**KIRKLEES METROPOLITAN COUNCIL  
INVESTMENT & REGENERATION SERVICE**

**DELEGATED DECISION TO DETERMINE PLANNING APPLICATIONS**

Reference No:	<b>2023/62/92779/W</b>
Site Address:	Chicken Cottage, 23, Cross Church Street, Huddersfield, HD1 2PY
Description:	Erection of single storey rear extension, alterations to upper floors to form 2 apartments, alterations to frontage to create additional entrance, internal and external alterations (Listed Building within Conservation Area)
Recommending Officer:	Katie Chew

**DECISION - REFUSED**

04 - PROPOSED FRONT ELEVATION.
Scale: 1:100

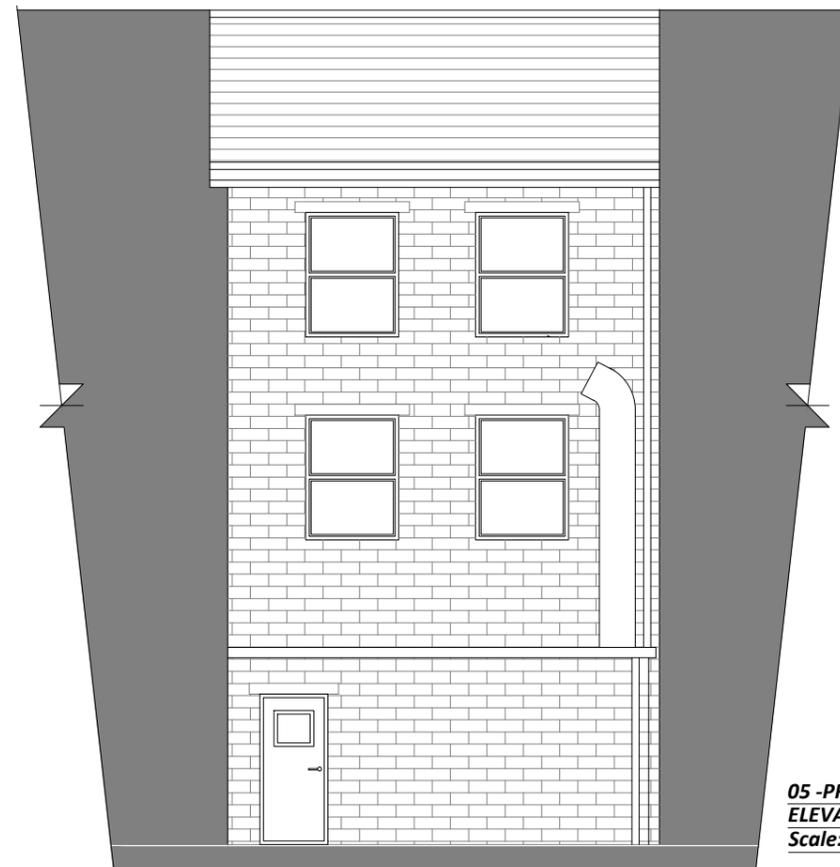
Windows and doors are to remain as is, albeit new rooflights are proposed to be installed within the front and rear roof slopes (although these are not shown within the elevation plans). Whilst Conservation style roof lights may be acceptable further details would be required to enable Officers to assess the proposals and any impacts they may have on the Listed Building or Conservation Area.

**02 PROPOSED FIRST FLOOR PLAN.**  
Scale: 1:100

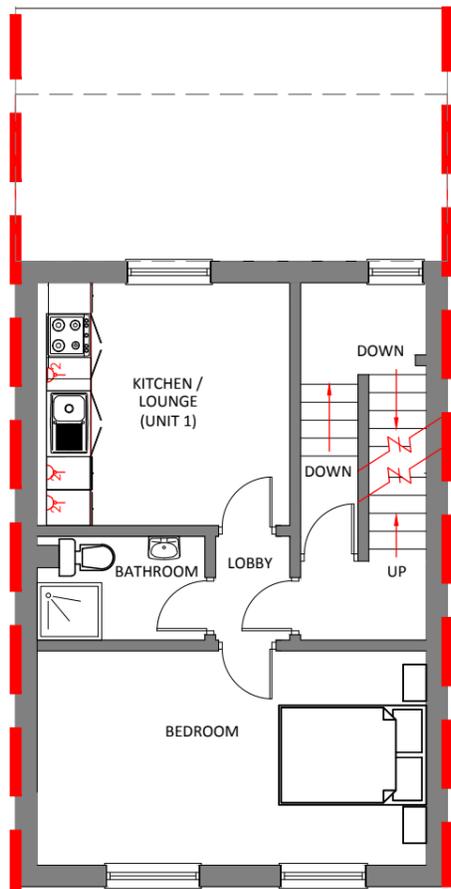
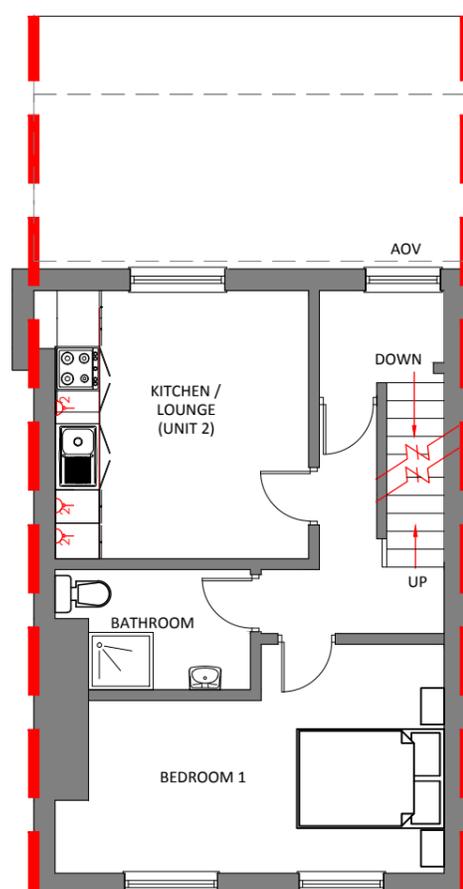
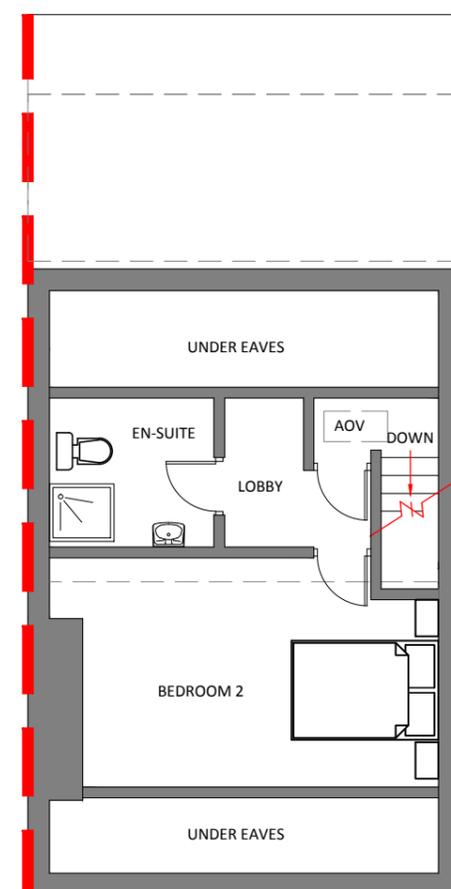
As outlined at the start of the report, Apartment 1 is to provide one double bedroom, with a floorspace of around 45sqm. Apartment 2 is to provide two double bedrooms, with a floorspace of around 61sqm. Both of these apartments would fall short of the minimum gross internal floor areas outlined within the NDSS, in addition to this, bedroom 2 of Apartment 2 would only have access to rooflights, which would provide natural light into the rooms but would provide a limited outlook for any future occupiers. Officers therefore do not consider that the apartments would provide a good standard of amenity for future occupiers, contrary to LP15 and LP24 of the Kirklees Local Plan.
